**Case Officer:** Imogen Hopkin

**Applicant:** Miss Joannafey Mills

**Proposal:** Demolition of existing dwelling and erection of a replacement detached dwelling including the partial removal of existing outbuildings, replacement outbuildings, proposed swimming pool and associated landscaping

title	PROPOSED HOME STUDIO
project	New Barn Farm
client	J. Mills
scale	1:50 @ A1 / 1:100 @ A3
date	Aug 2023
drawn	FP
checked	CF
status	Planning
job number	359
drawing number	015/A

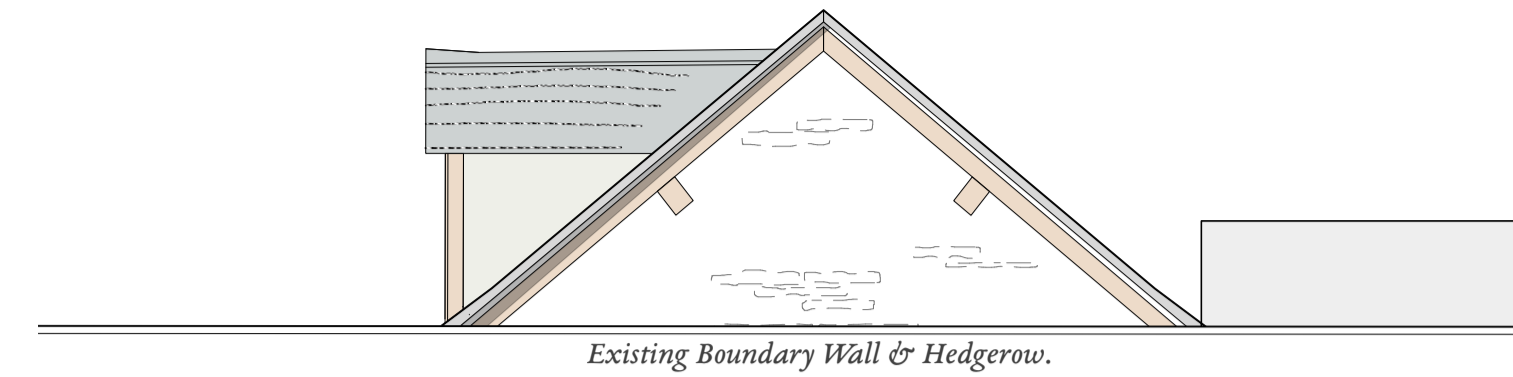
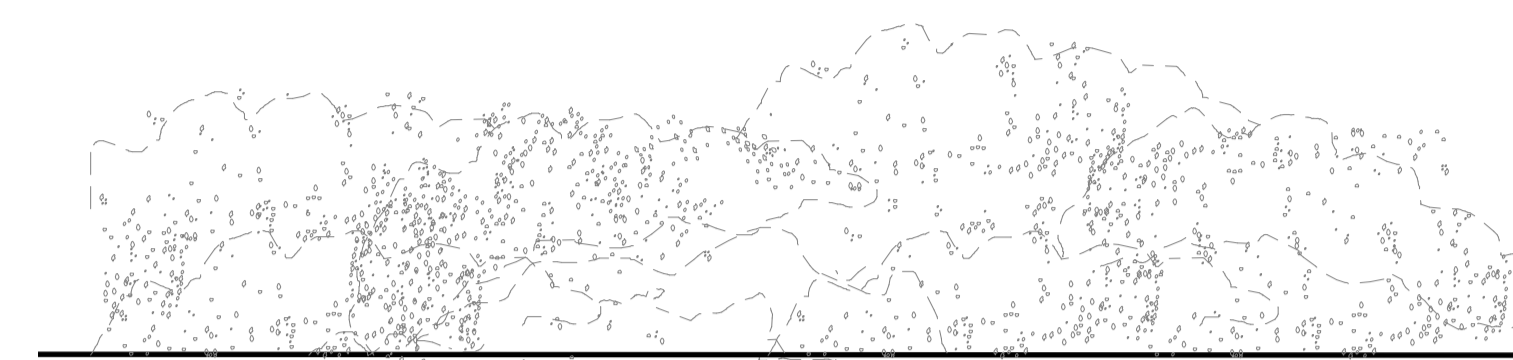
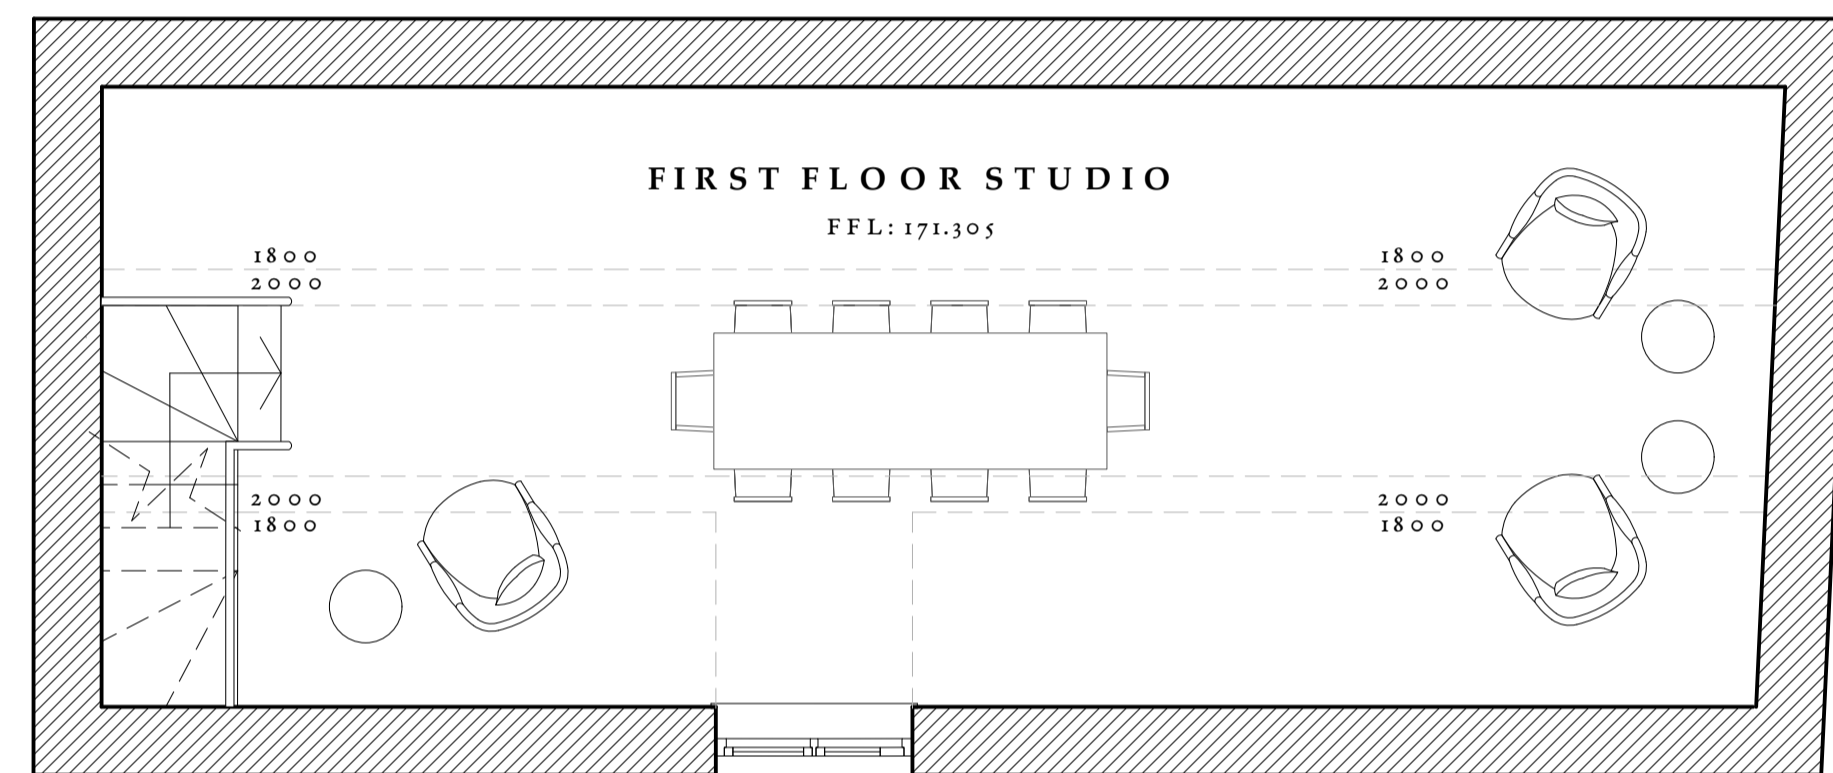
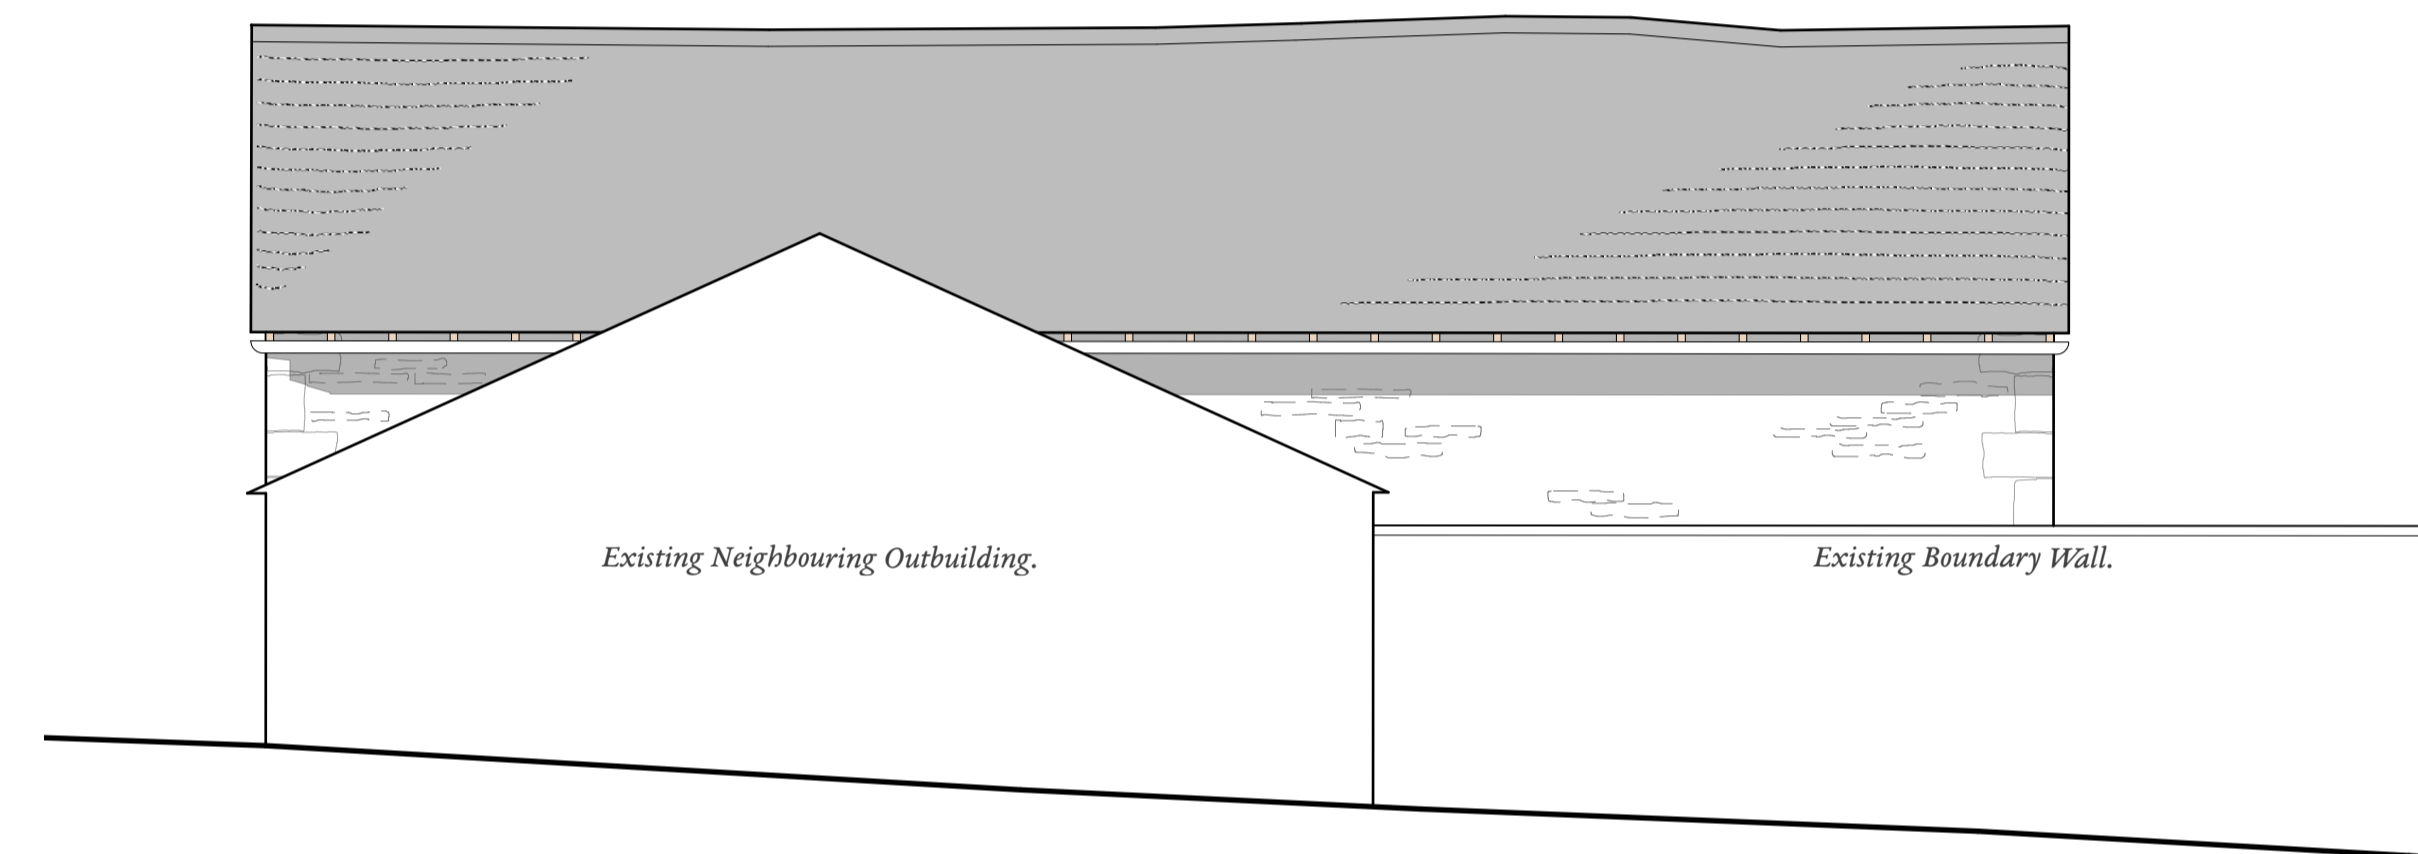
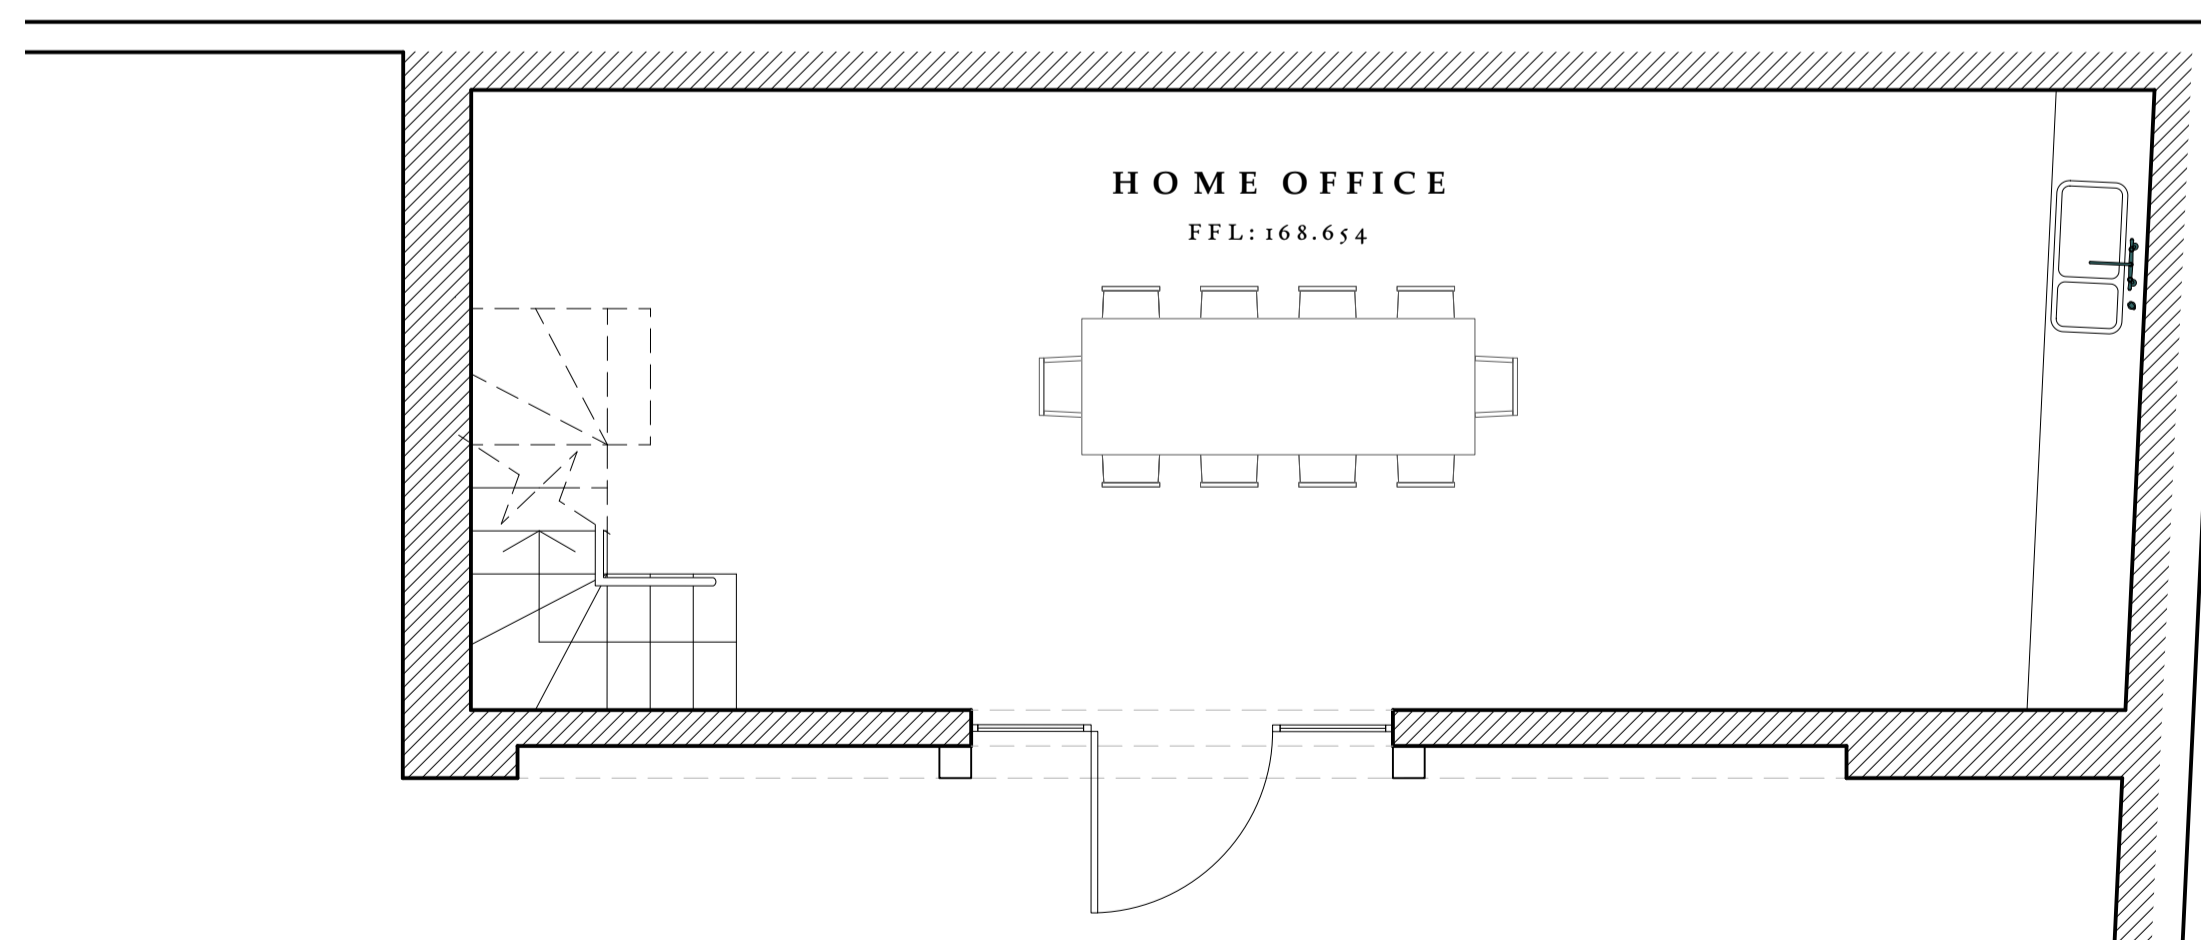
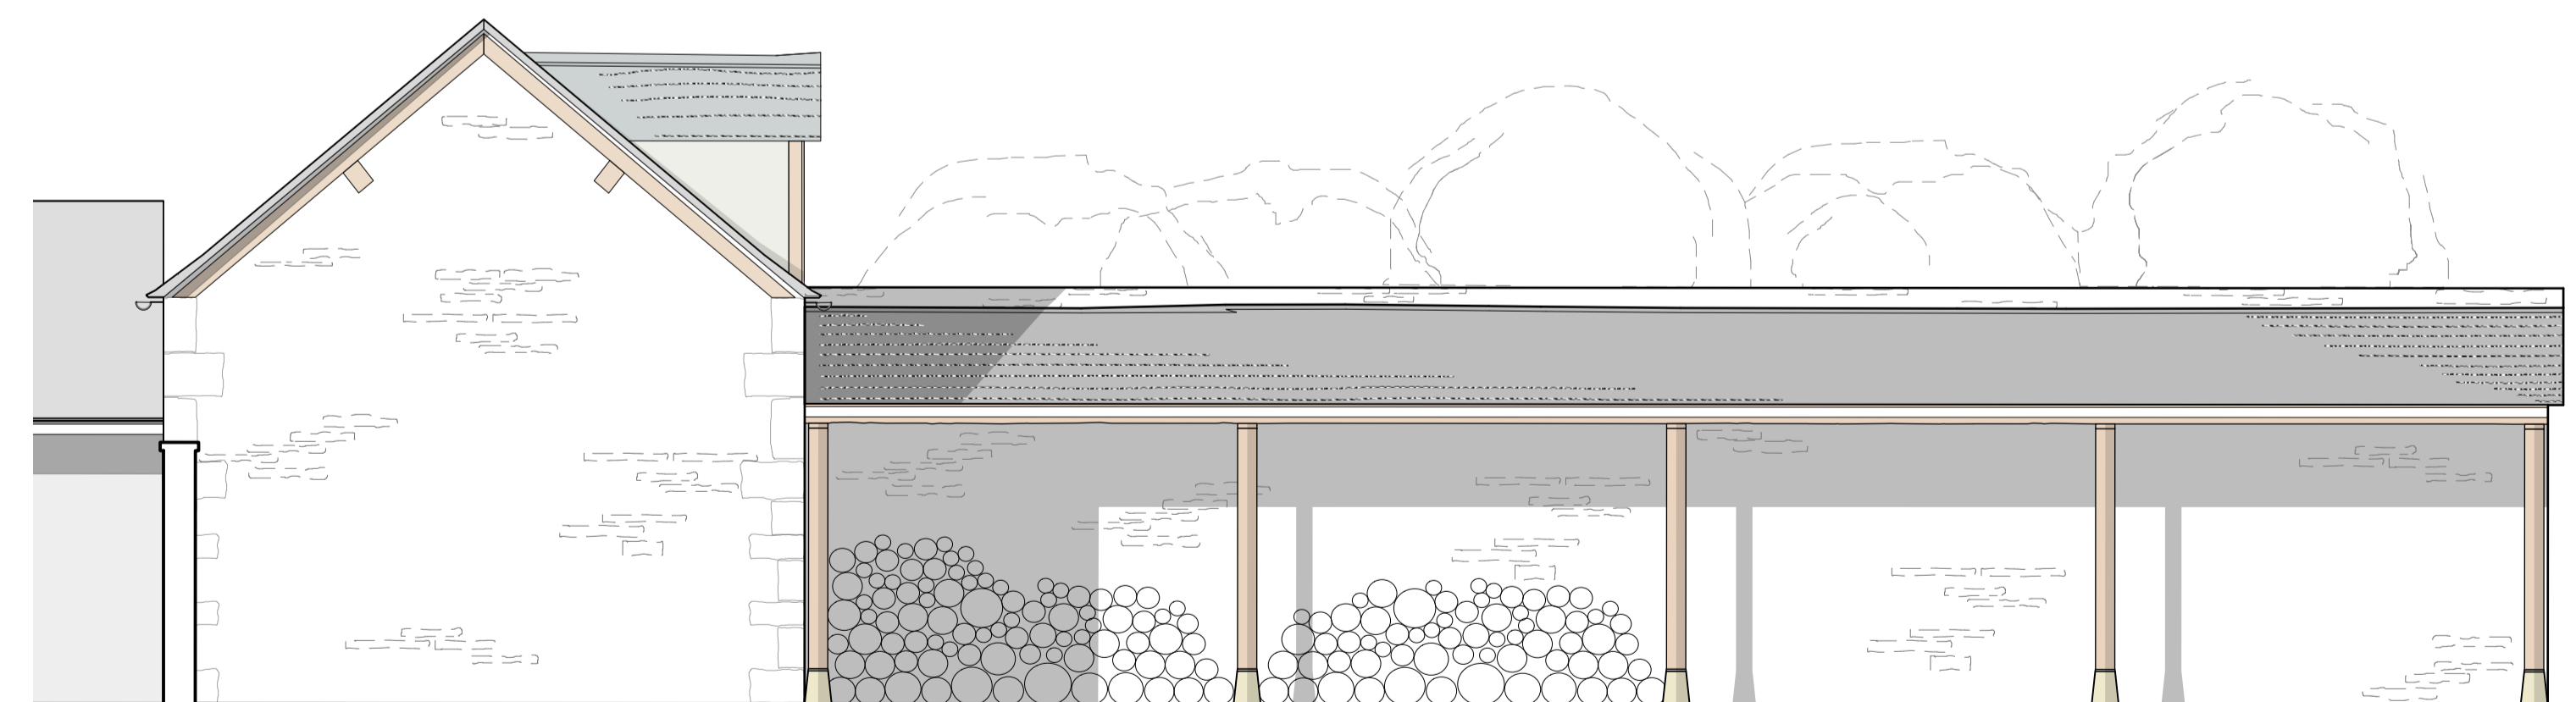
- 8.17. The proposed detached outbuilding to provide office space ancillary to the dwelling is an acceptable bulk and massing, as the proposed building has been reduced in height. The outbuilding is proposed to have a mix of stone and timber cladding. While timber cladding is not usually acceptable, there are existing elements of timber cladding within the site, so the principle of a small portion on this outbuilding would be acceptable, subject to details. The position of this building is 31m from the main dwelling. While there is a separate-ness to the building, there are no toilet facilities within this outbuilding, so there is a reliance on the main dwelling. This building is therefore acceptable, on balance, subject to a condition to require it to remain ancillary to the main dwelling and ensure it would not be converted, sold or sub-let.

- 8.22. The position of the replacement dwelling would not result in a detrimental impact to neighbouring properties, with no loss of privacy or overshadowing. The proposed office and studio outbuilding has an eaves height of 3.3m and a ridge height of 5.3m. The outbuilding abuts the boundary between the neighbouring outbuilding, which is adjacent to a parking area. As such, while this would have a visual impact to the neighbouring property, it would not result in any overshadowing or loss of outlook from Sibford Park.

10. The detached ‘Barn and Byre’ (drawing number 012 Rev B) and ancillary office and studio building (drawing number 015 Rev A) shown on the approved plans or any amendment to those plans shall be used solely for purposes ancillary to the enjoyment of the main dwelling and shall not be sold or leased separately from the main dwelling and at no time shall form a separate planning unit.
